Rezoning Transportation Analysis

Petition Number: 2021-119

Revision Log:

SHEET NUMBER  
**RZ-1**

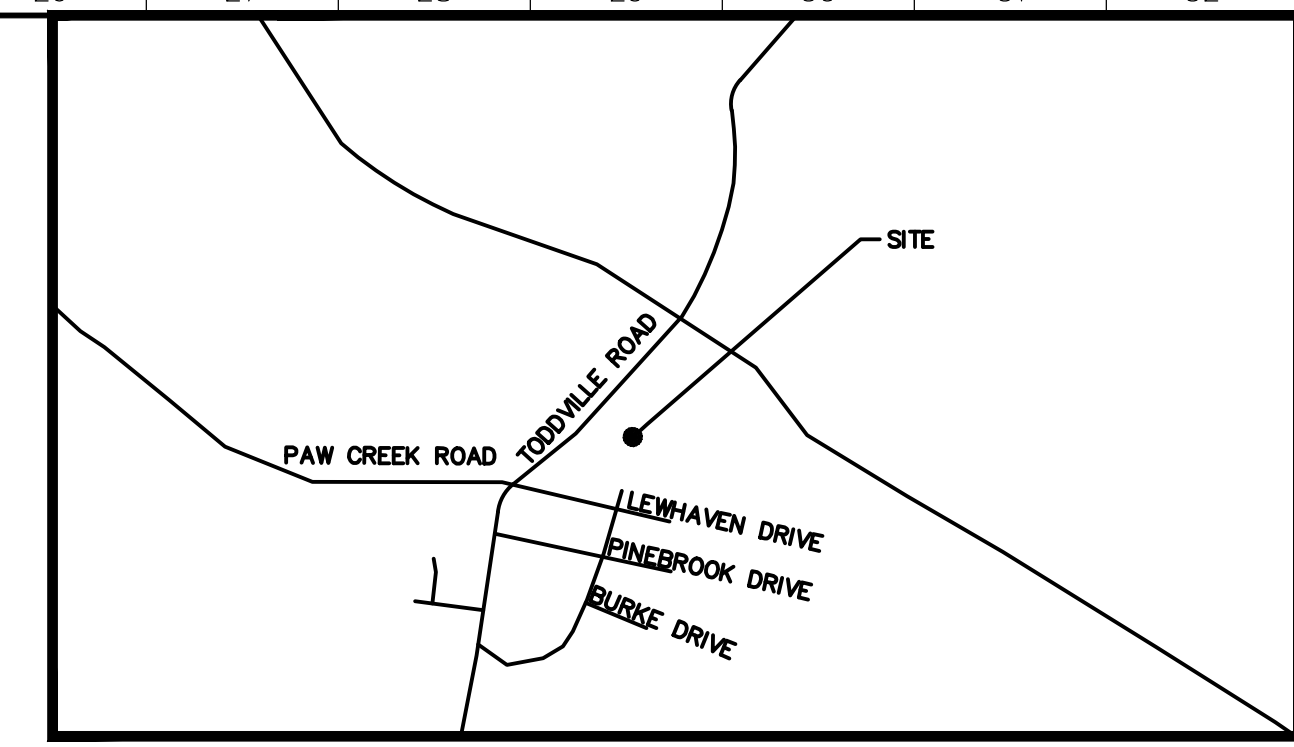
11. **New Comment as a result of the 11-15-2021 Site Plan:** Revise the site plan by modifying the U-02 cross section, shown on sheet RZ-1, to incorporate 6-foot sidewalks as labeled and dimensioned on the site plan.

10. ~~**New Comment as a result of the 11-15-2021 Site Plan:** Revise the site plan and conditional notes to commit to provide right in right out ingress and egress at the intersections of Private Alley D and Public Street A and Private Alley A and the approved public street associated with the Freedom Flats Multifamily Development (LDGP-2020-00201). A porkchop island shall be utilized on Private Alley D~~

and Private Alley A, with appropriate ADA pedestrian accommodations, to direct the right in right out movements.

Update to Comment as a Result of the 11-15-2021 Site Plan: Revise Site Plan Note 2 to: "Developer will coordinate with NCDOT, during permitting, to construct a left turn lane on northbound Freedom Drive to turn onto Woodford Lane. The left turn lane will be subject to NCDOT standards and approval!"

SHEET NUMBER
RZ-1

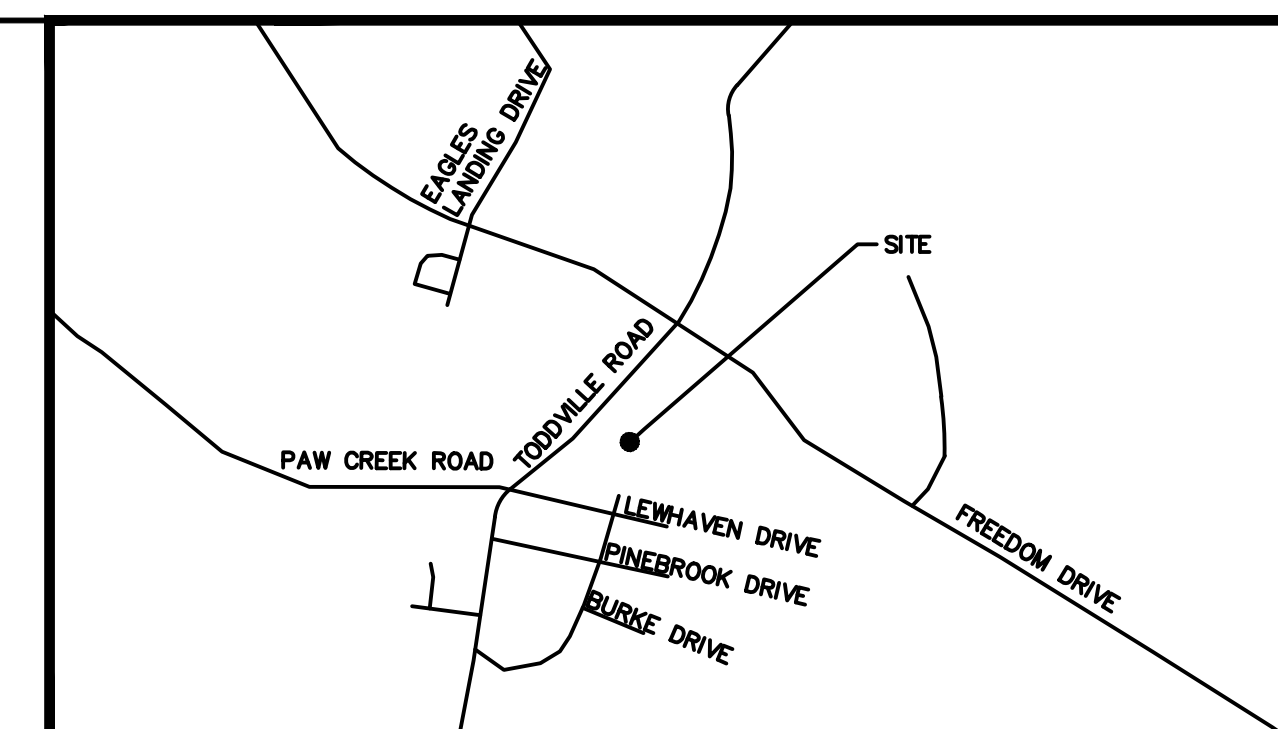
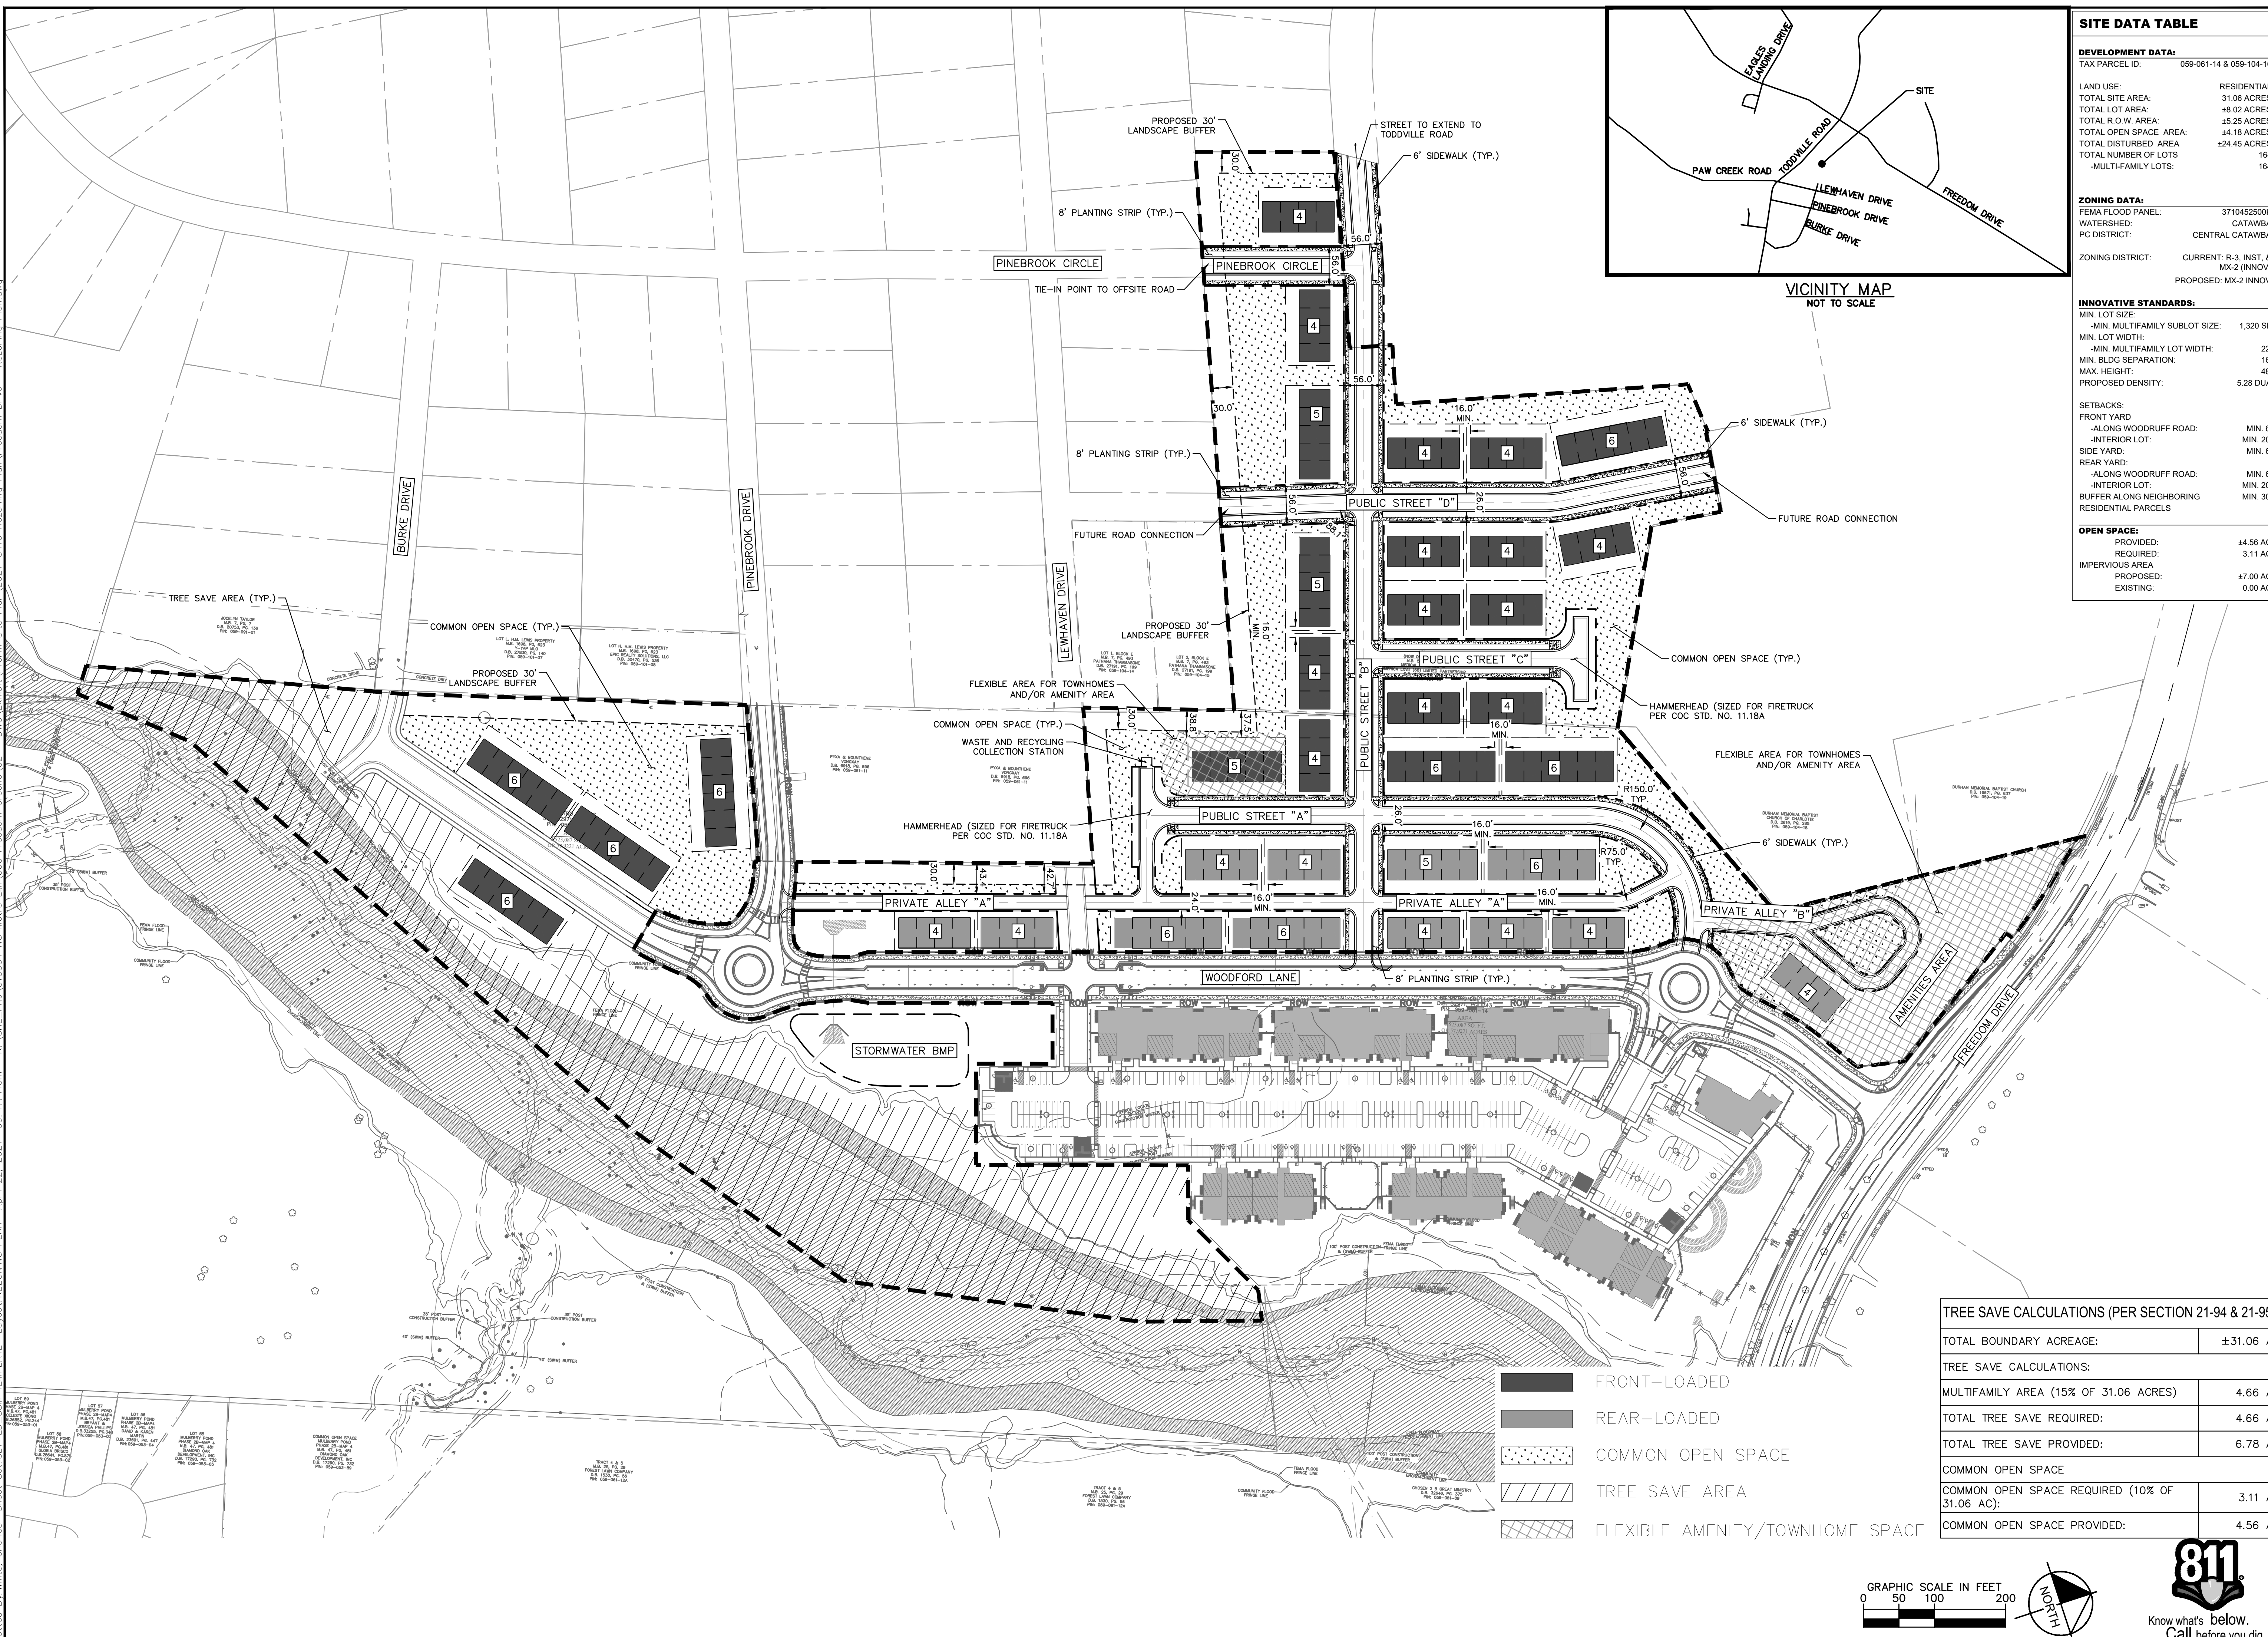
3. ~~Revise site plan and conditional note(s) by committing to connecting proposed Public Street B to existing Leaf Tree Drive. This connection will be subject to CDOT approval during permitting.~~

4. ~~Revise site plan and conditional note(s) by committing to extend the sidewalk along proposed Public Street B, and existing Leaf Tree Drive, and connect to the existing sidewalk at the intersection of Toddville Road and Leaf Tree Drive. Additionally, the appropriate PROWAG and ADA curb ramps will be constructed at the intersection of Toddville Road and Leaf Tree Drive.~~
